15/04/2020

**University of Newcastle STEMM Building (SSD-9832)
Response to Submissions**

ATTACHMENT 1

TREE REMOVAL PLAN
ALL PROJECT STAGES

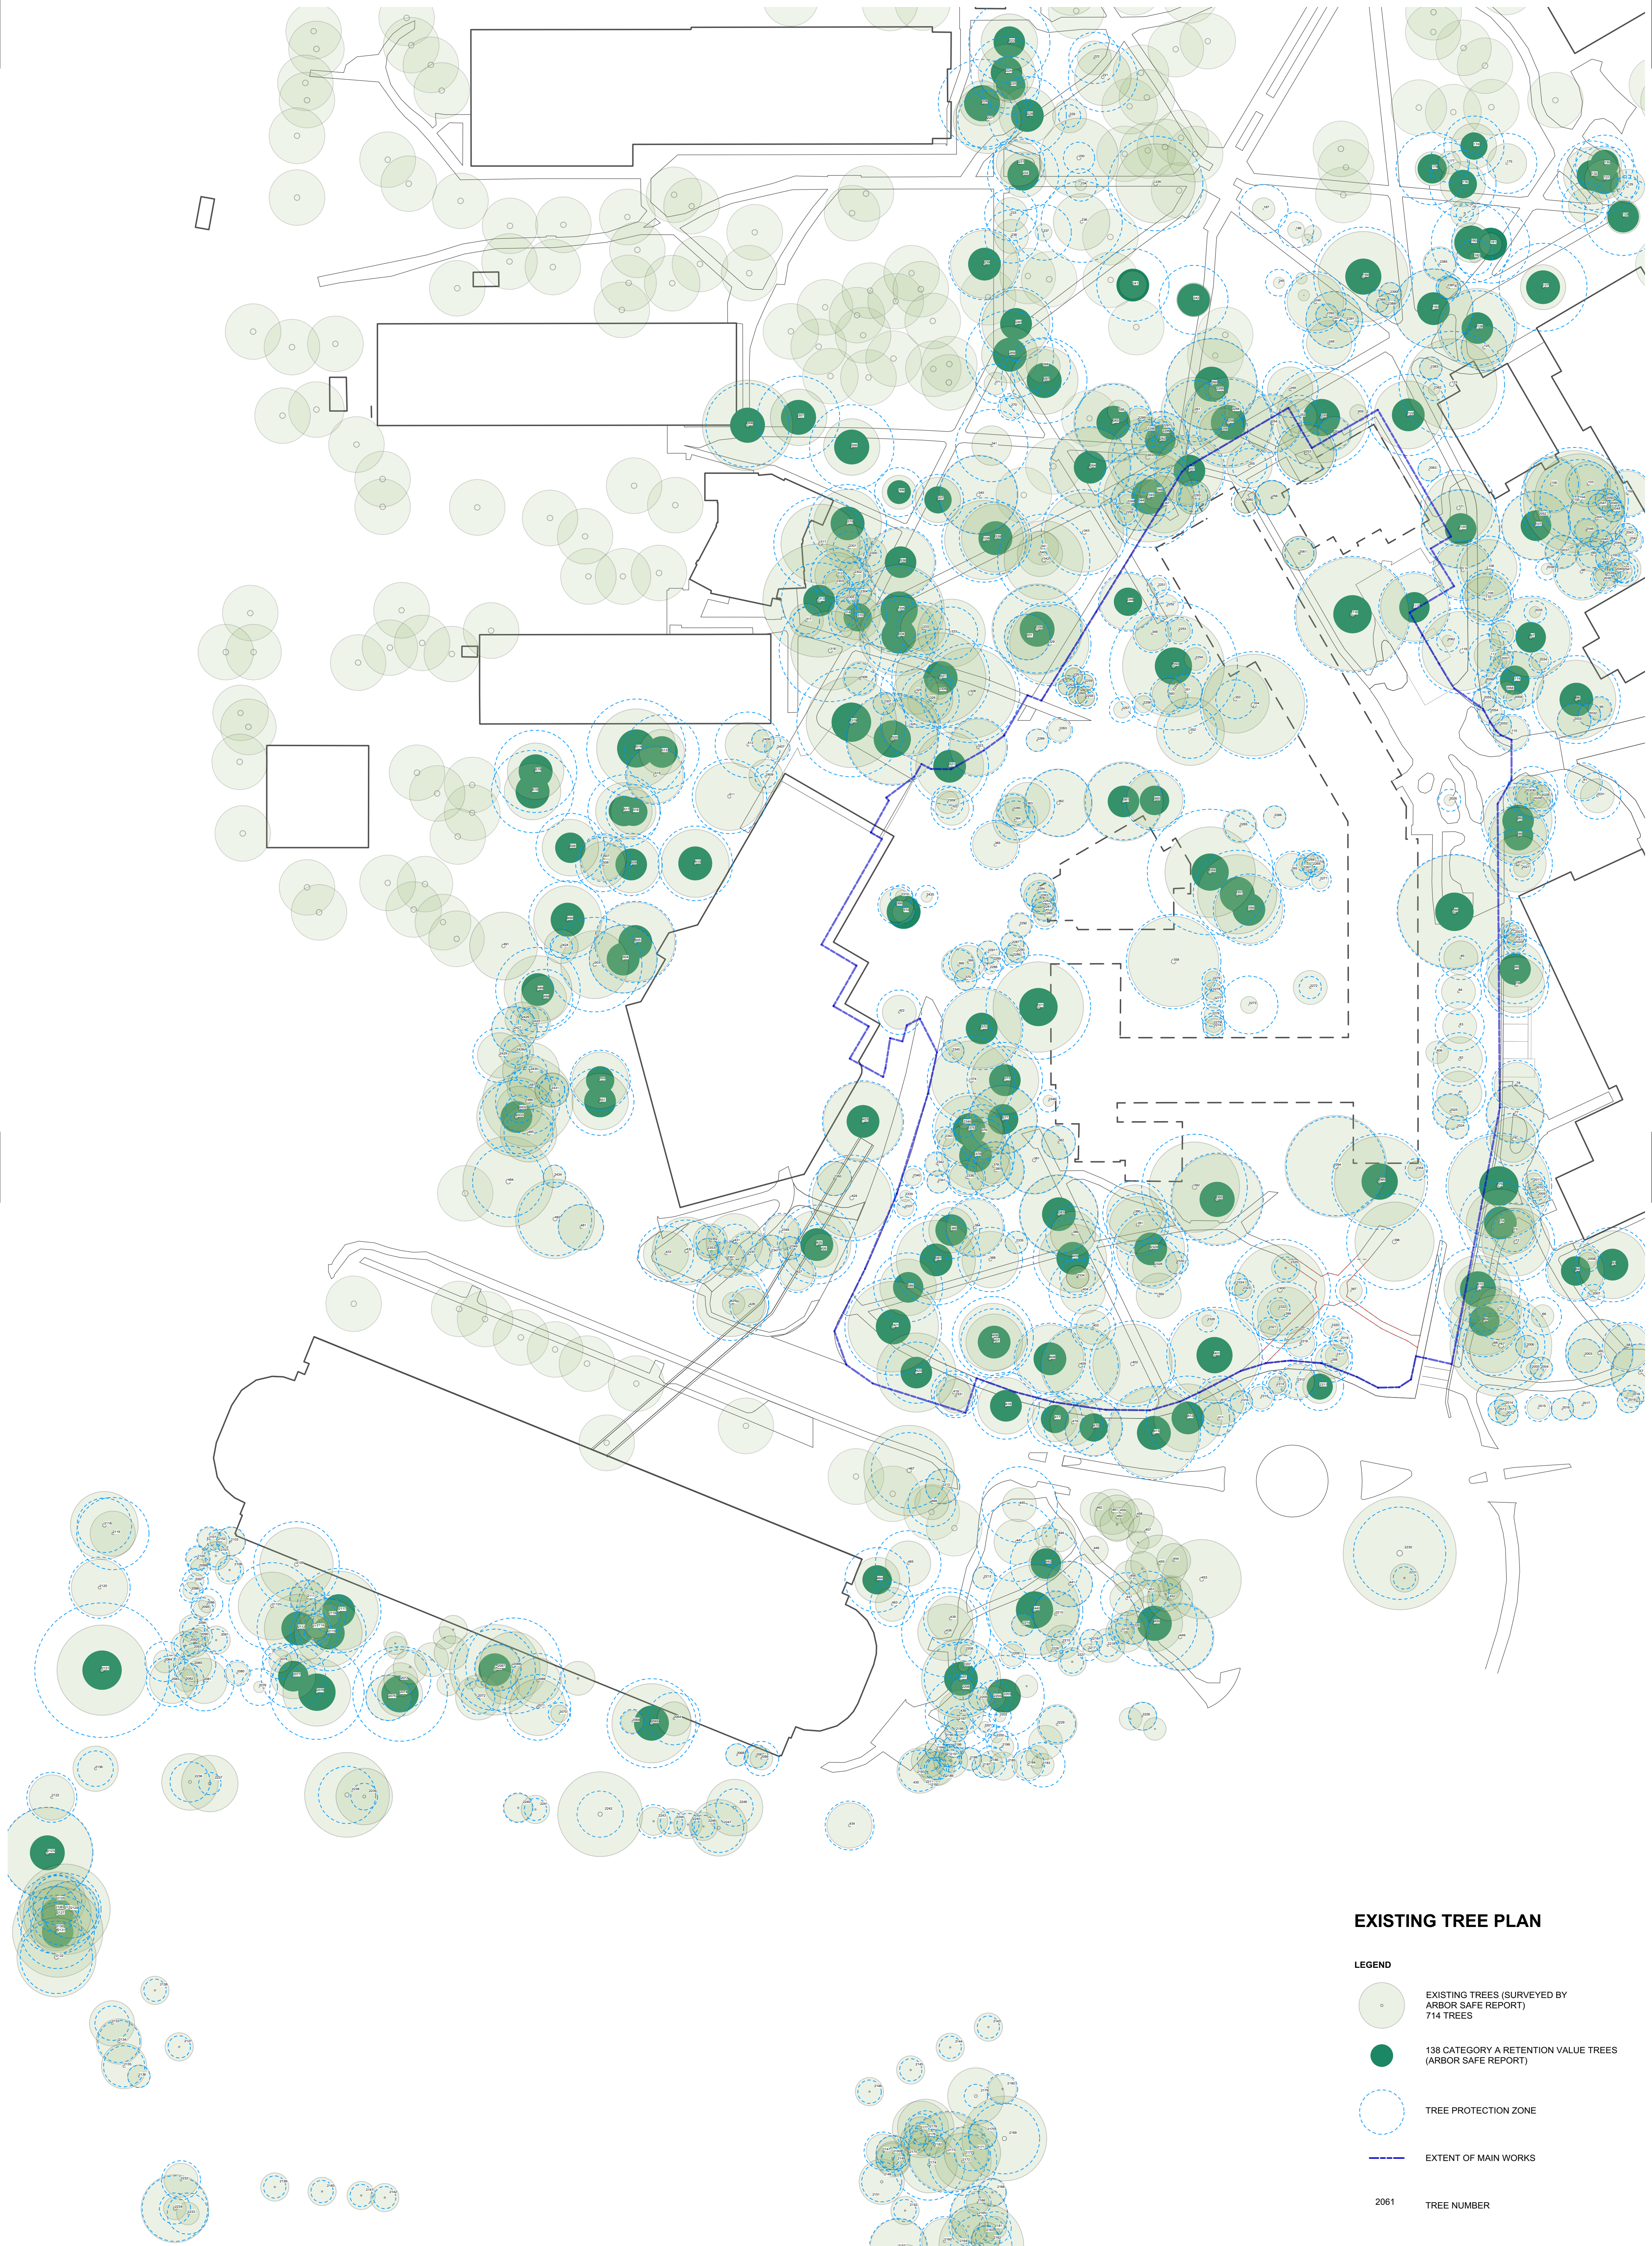
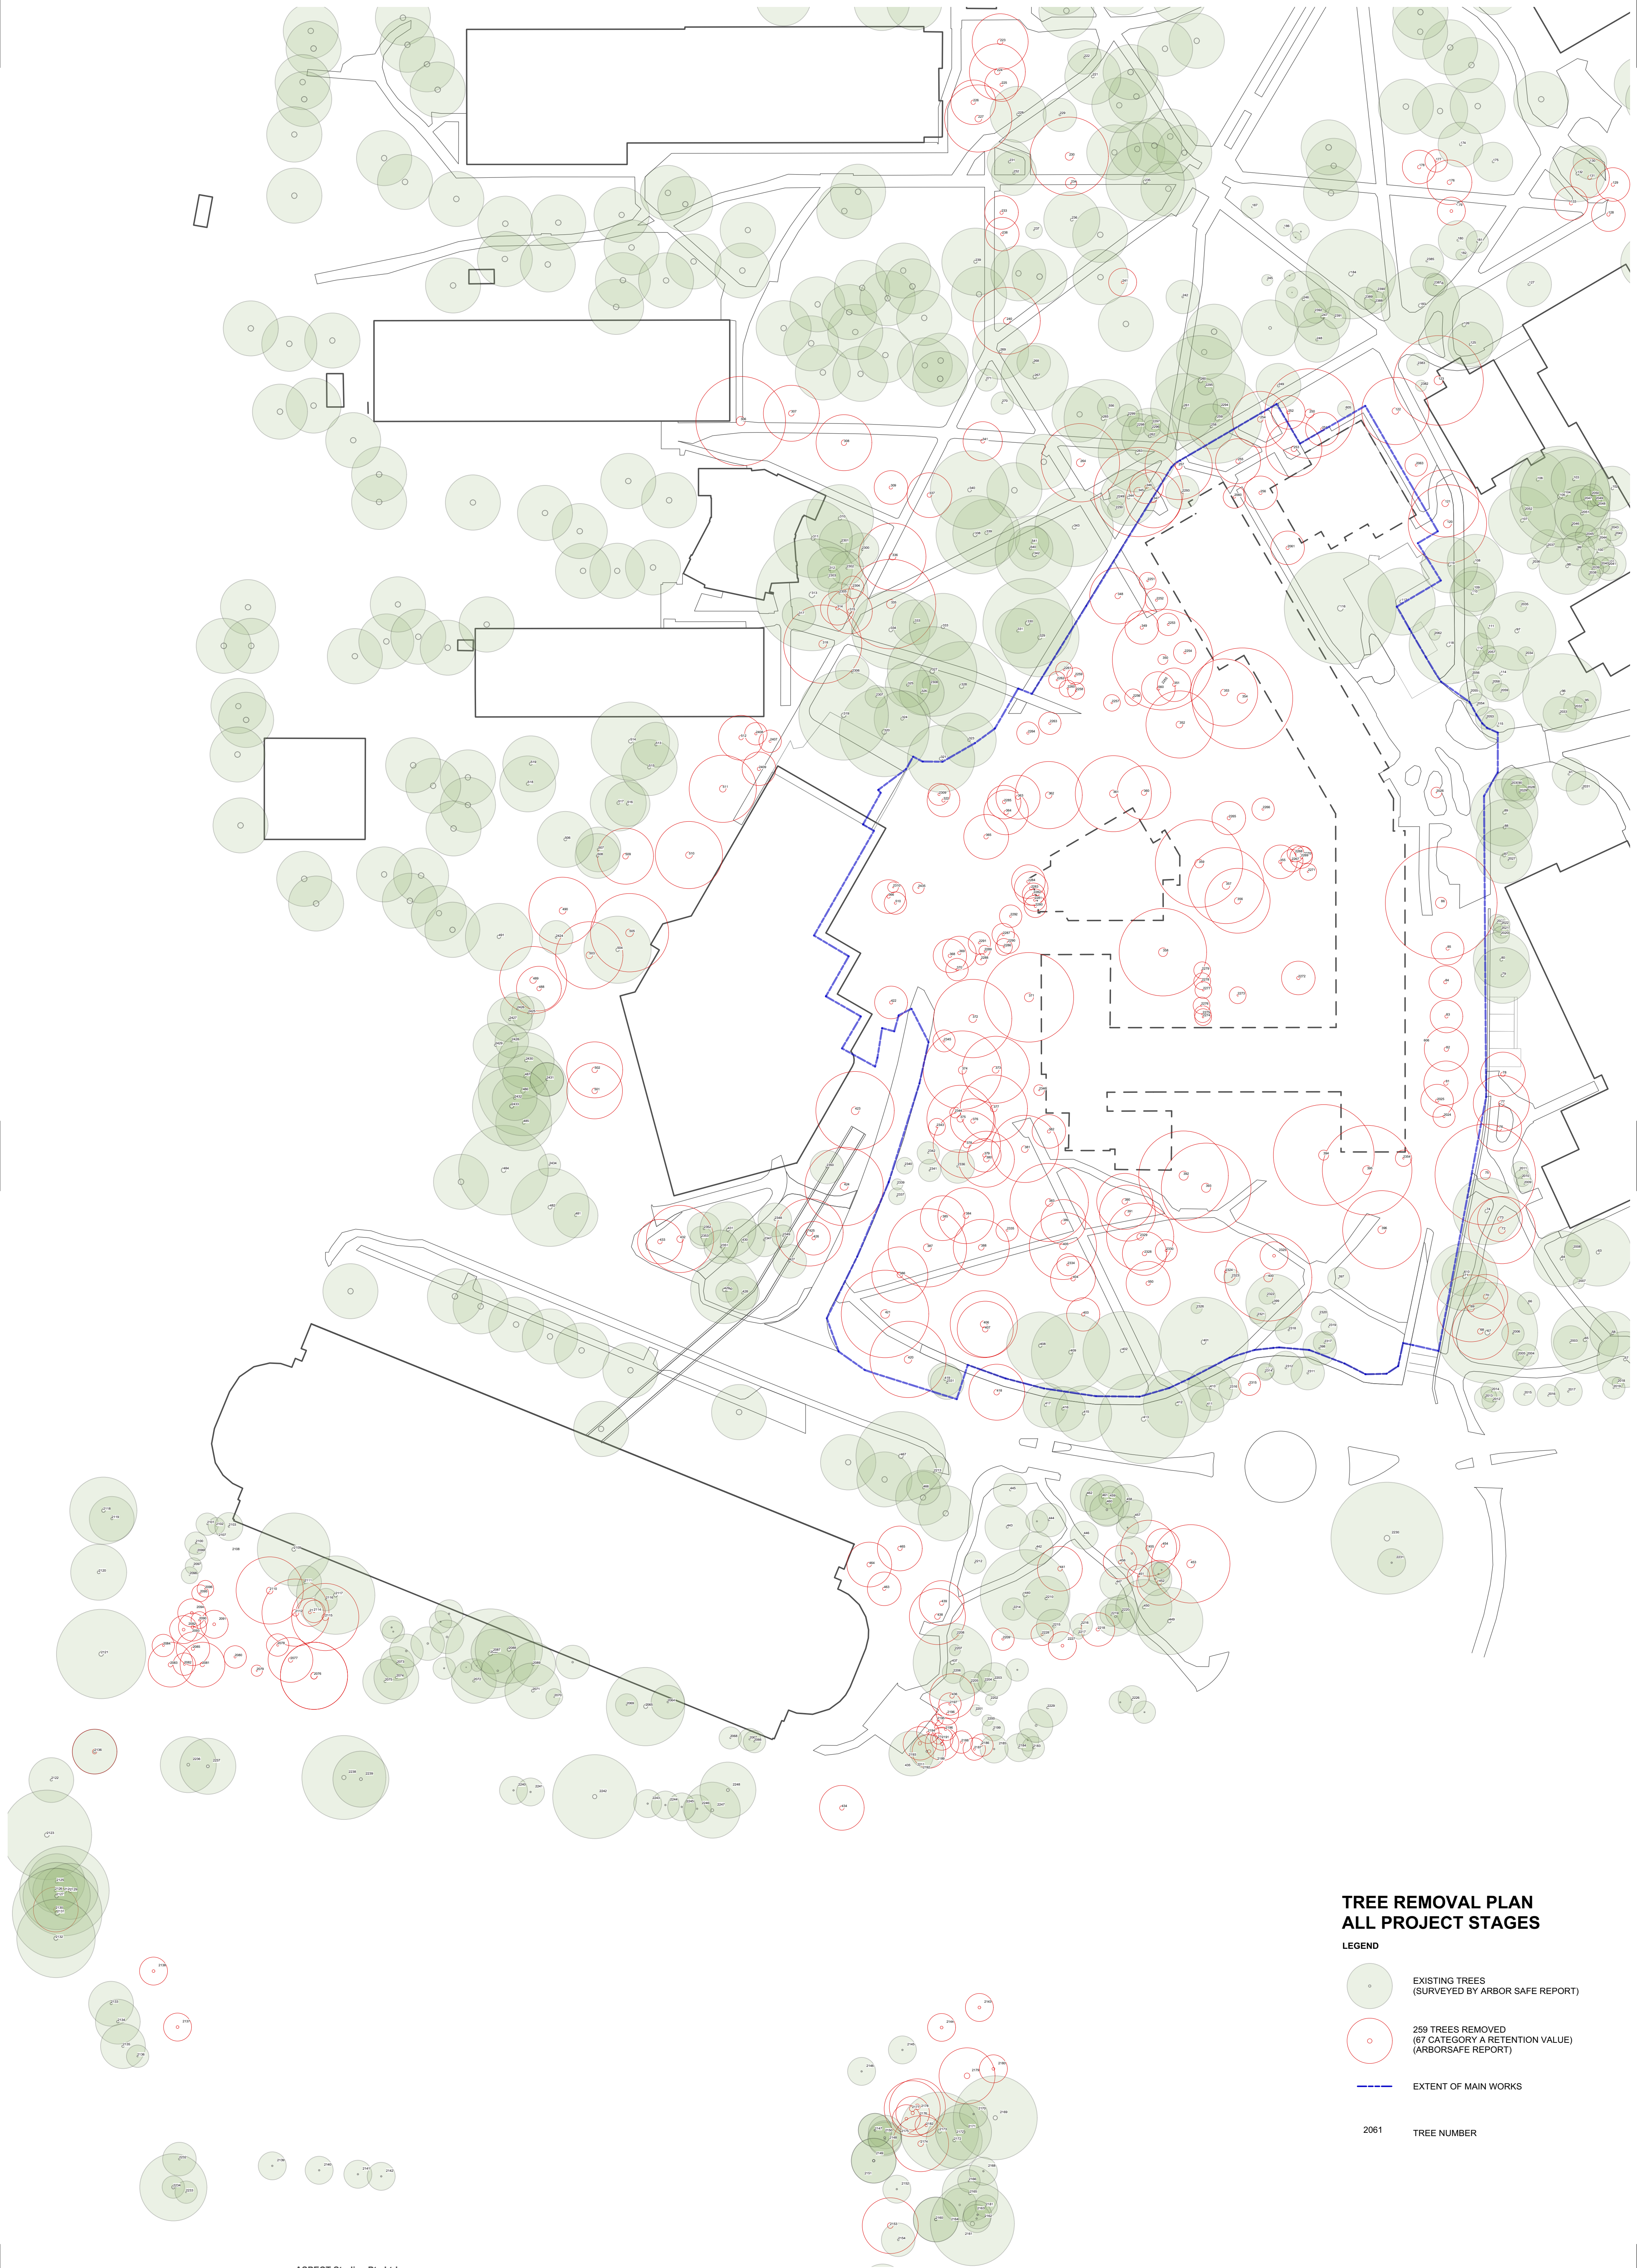
- provide Appendix D of the BDAR (Biodiversity Credit report).
- provide clarification of the number and location of existing trees and those being proposed for removal as the tree plan submitted (Appendix L pg. 8) does not match documentation presented to the State Design Review Panel.
